From: [Guymer, Tim](#)
To: [Aquind Interconnector](#)
Cc: [Drury, Holly](#); [Stickland, Caroline \(Solicitor\)](#); [Murray, Chris \(Planning\)](#); [Richard Turney](#); [Hirst, Chris](#); [Ackerman, Ian](#)
Subject: EN020022 Aquind Interconnector - Deadline 8 submission from Hampshire County Council (Reference: 20025080)
Date: 01 March 2021 16:58:57
Attachments: [6-3-6-400 Aquind Final HCC Deadline 8 Response Signed PDF.pdf](#)

Aquind Interconnector DCO - Deadline 8 submission of Hampshire County Council

Hampshire County Council has completed its review of the drafting of the Aquind Interconnector Development Consent Order (DCO) and the accompanying documentation as submitted by the applicant to the Examining Authority as of 26 February 2021. The County Council has also further reflected on the ISH4 and ISH5 hearings.

Appendix 2 – Converter Station Access Drawing

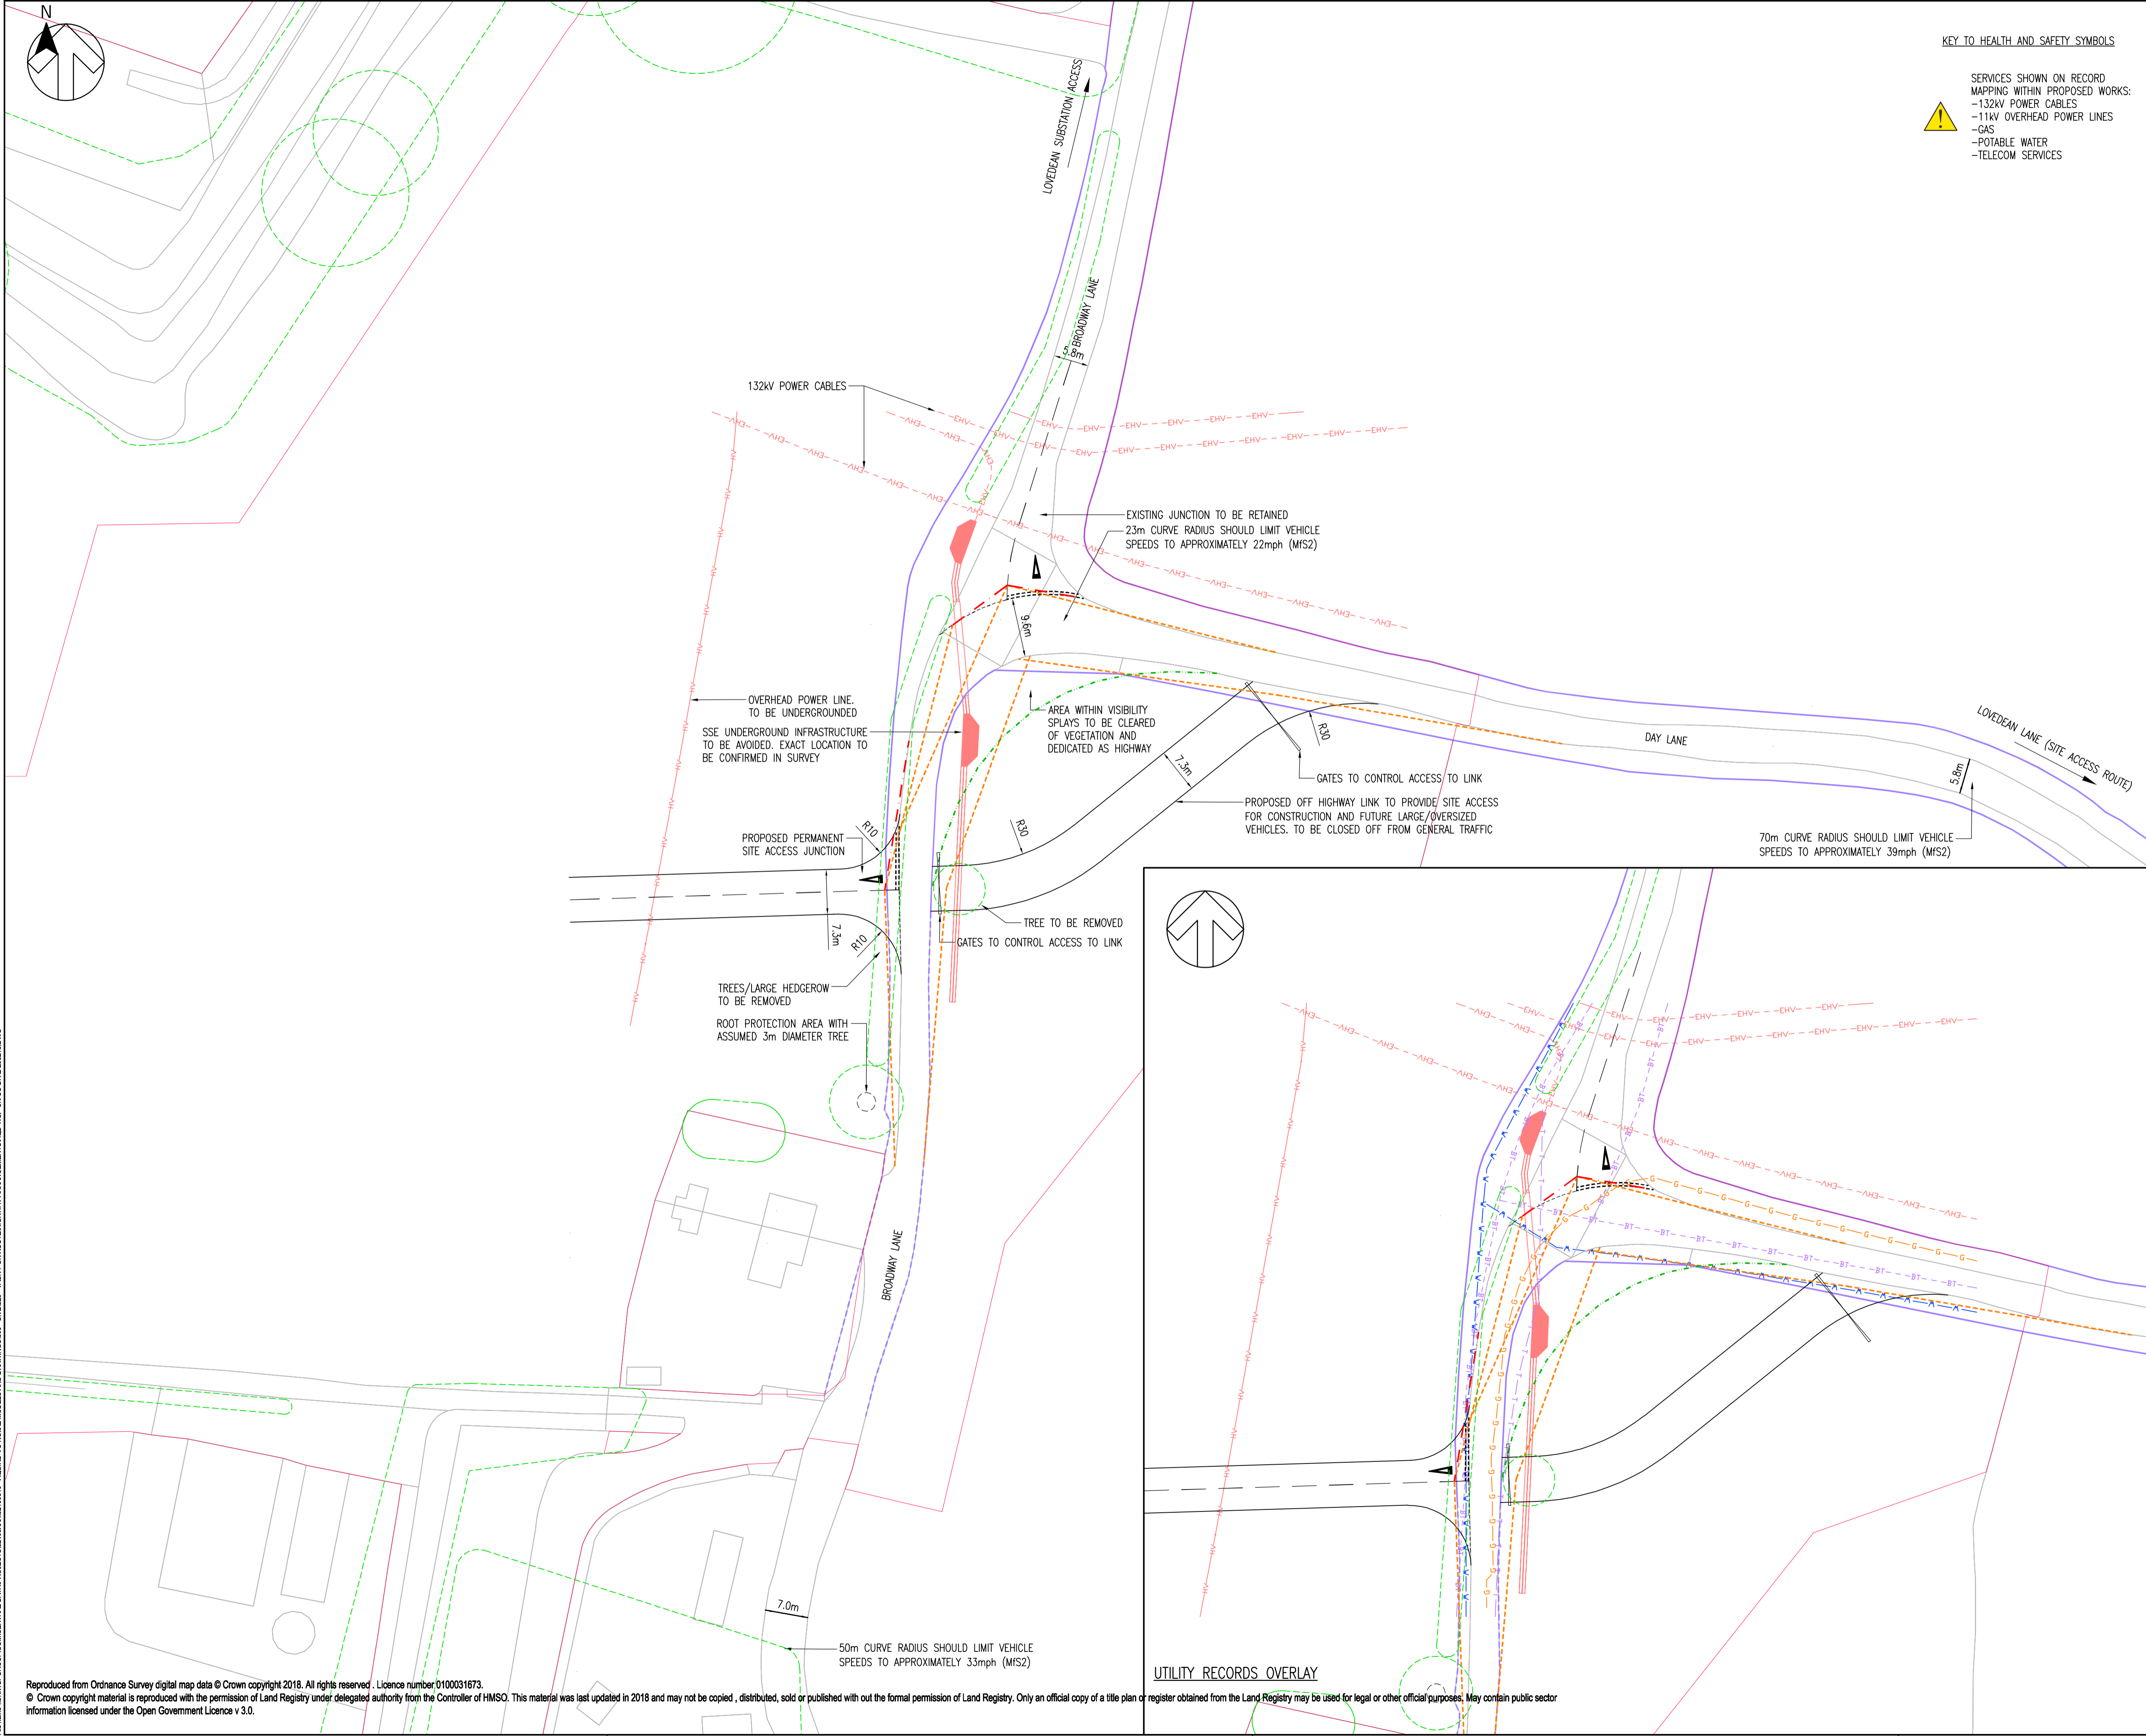
Appendix 2 – Converter Station Access Drawing

Appendix 2 of the CTMP details the site access works agreed through consultation with the Highway Authority. The extent of the works is detailed within drawing number AQD-WSP-UK-OS-DR-Z-200215 rev 06 and will be delivered through a S278 agreement with the Highway Authority. The site access works are supported by the provision of a 30mph limit. Further relevant drawings are appended to the Day Lane Management Strategy in drawing AQ-UK-DCO-TR-LAY-011.

Plate 5 – Typical Schematic of Joint Bay (distances in millimetres)

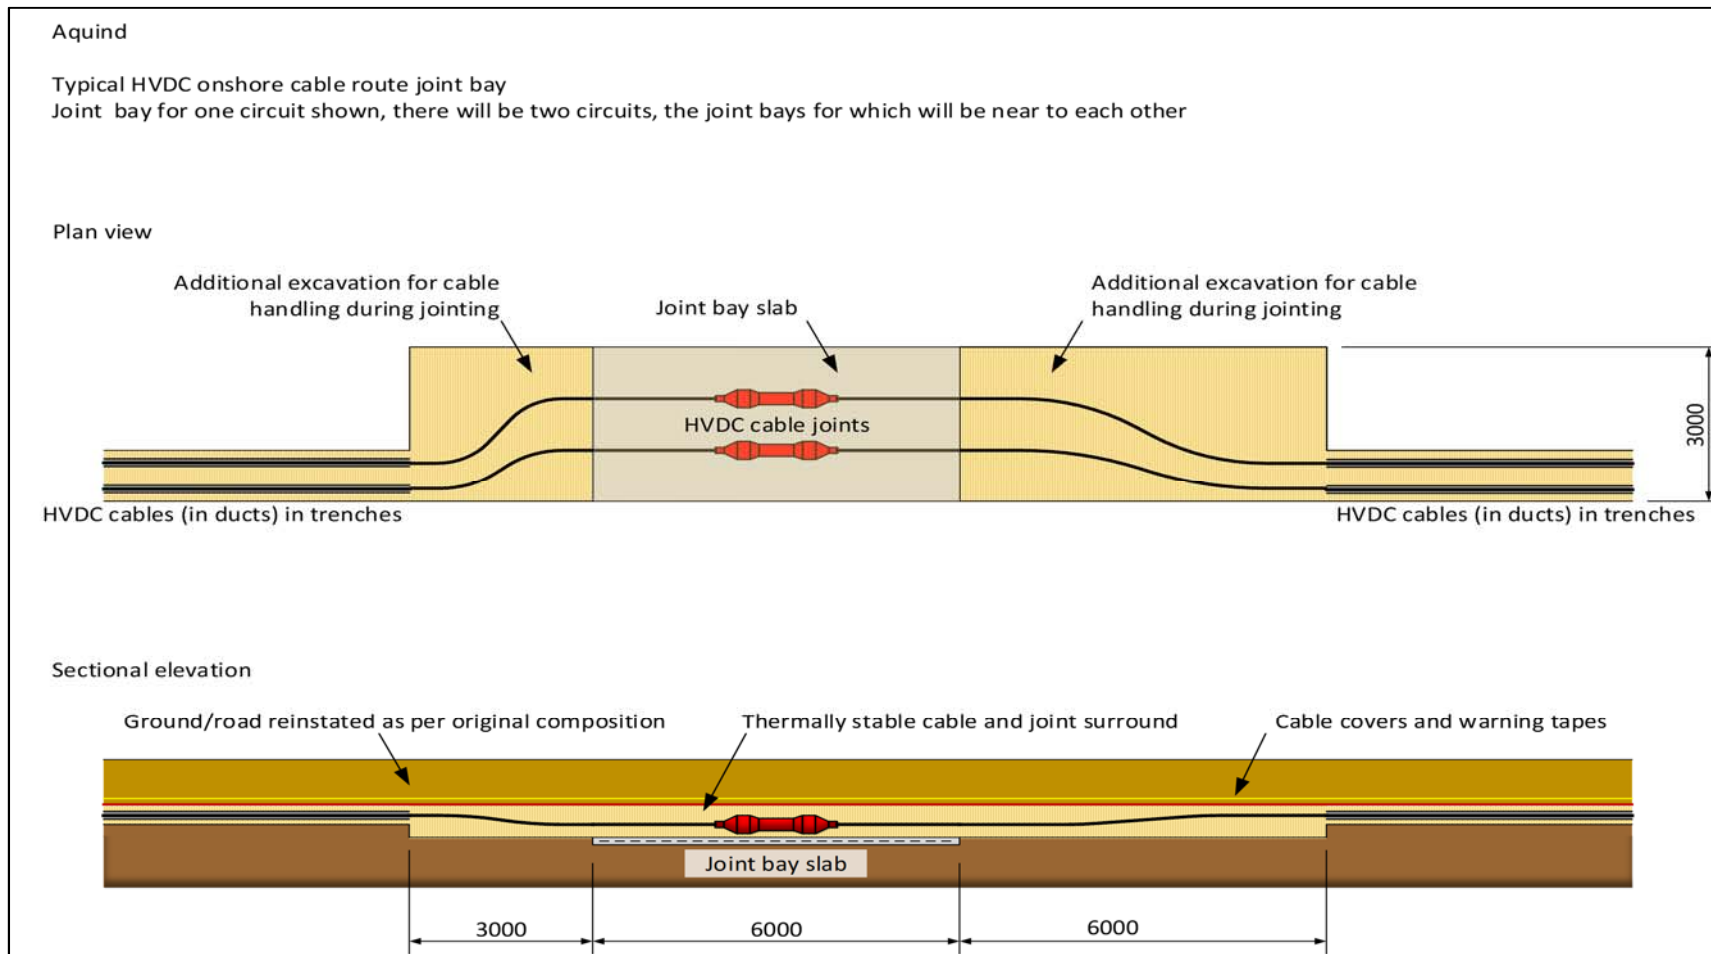
Joint Bays

Plate 6 - Proposed construction traffic management on Day Lane - will be replaced with full page image when issued as PDF

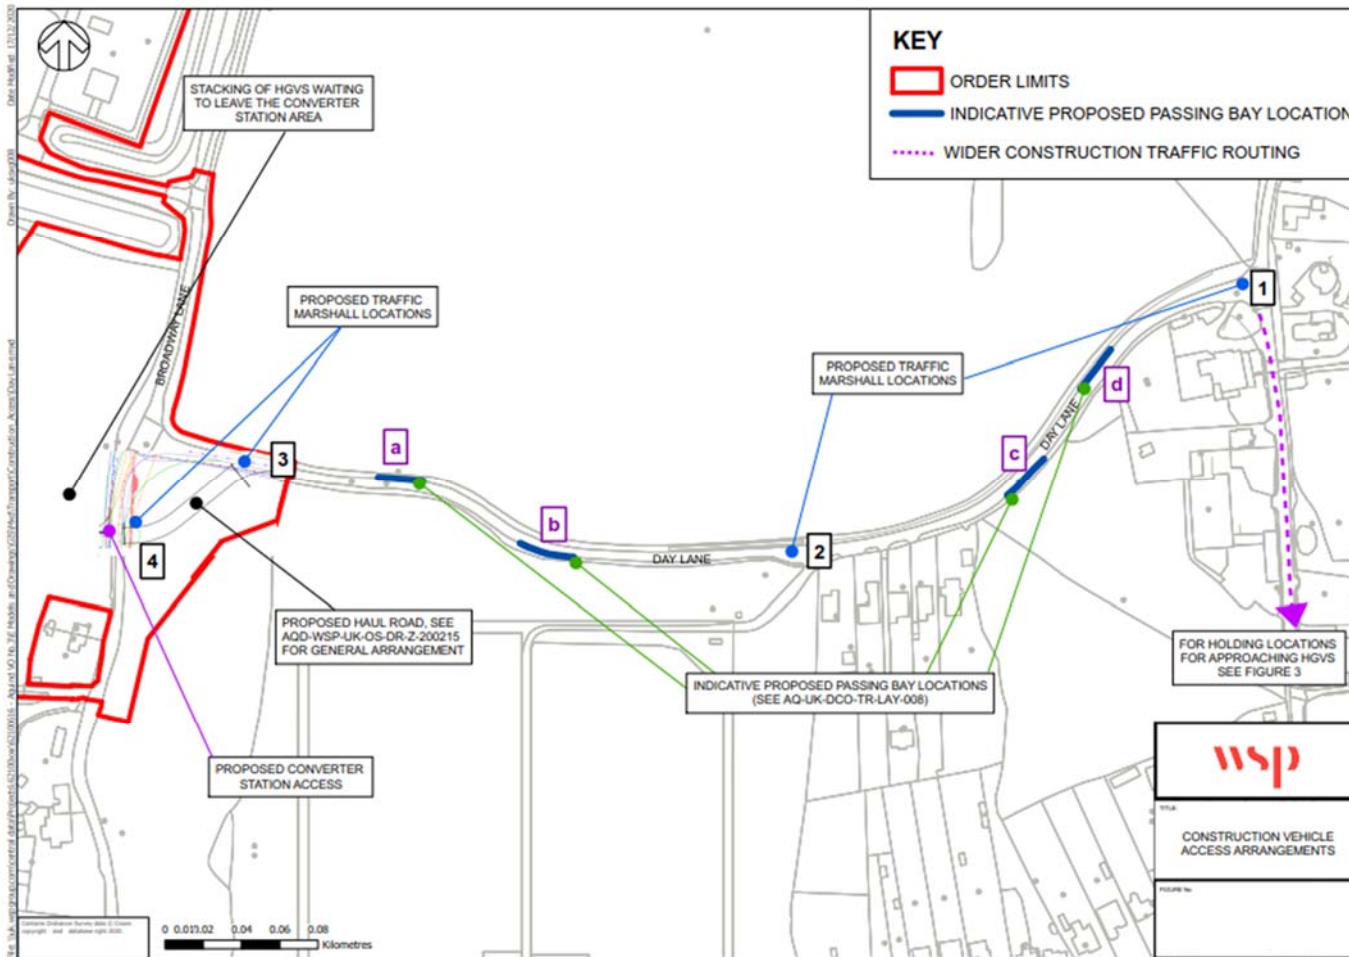
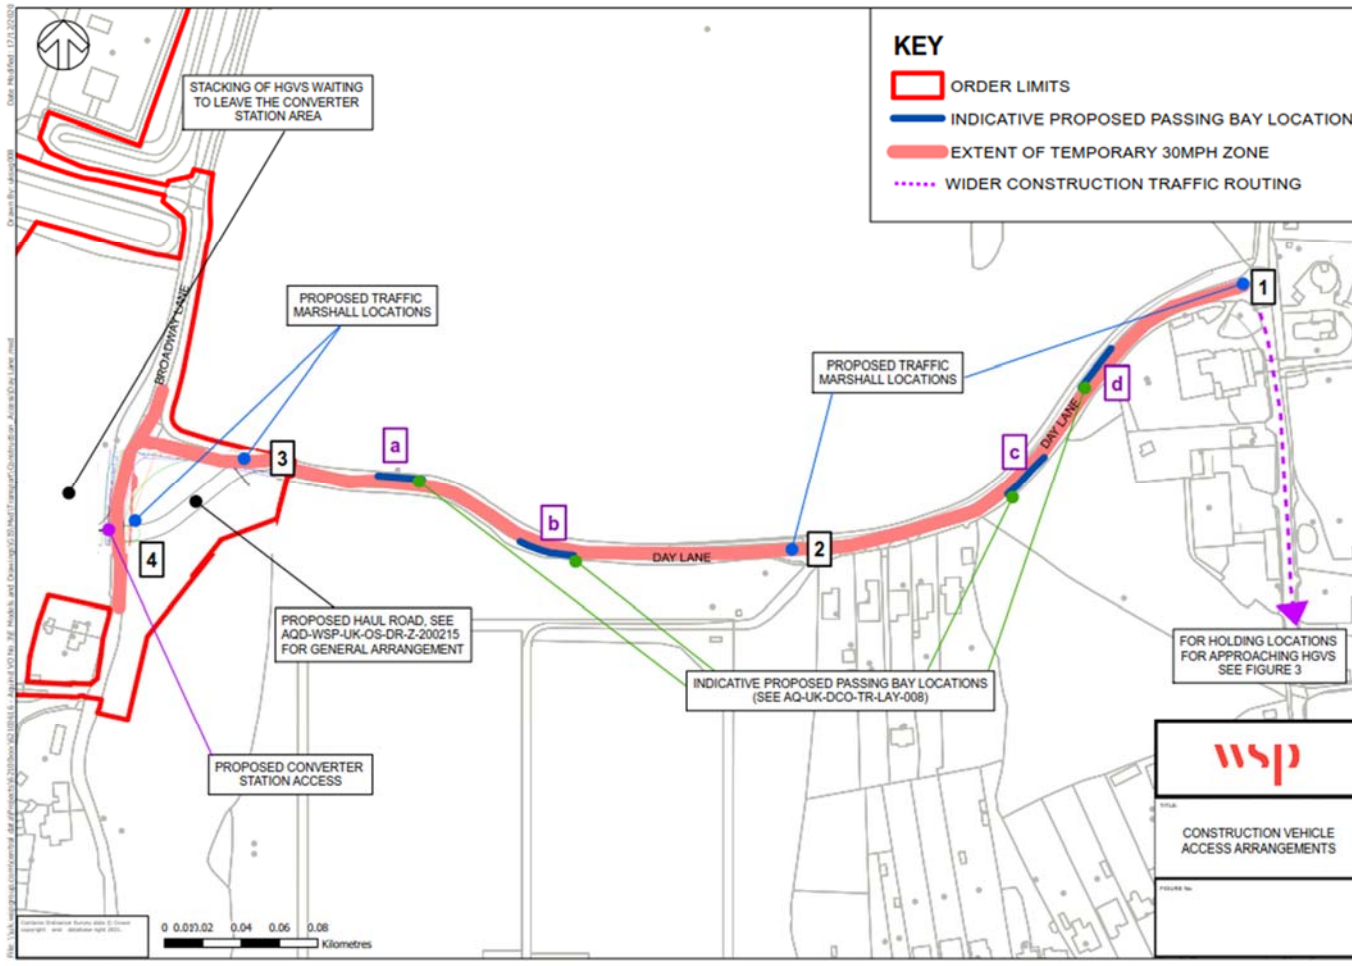
The document sets out the agreed strategy for managing inbound and outbound HGV movements to the site. Inbound HGVs will be co-ordinated to arrive in groups of 3 by first meeting at the Hulbert Road layby off the A3(M) Junction 3. The HGVs will be escorted by a lead vehicle which will control vehicle speeds on the approach to the site to 15mph. This will be supplemented by a Temporary Traffic Regulation Order (TTRO) along Day Lane which reduces the speed limit to 30 mph and the provision of traffic

marshals who will help to co-ordinate the use of STOP/GO boards to prevent the escort unexpectedly meeting an oncoming vehicle. Laybys will also be provided along Day Lane to provide dedicated passing places in the instance that the convoy meets an oncoming vehicle. The passing places will be delivered via a S278 agreement as detailed in drawing number AQ-UK-DCO-TR-LAY-008 Rev C which is secured under Appendix 9 of the CTMP.
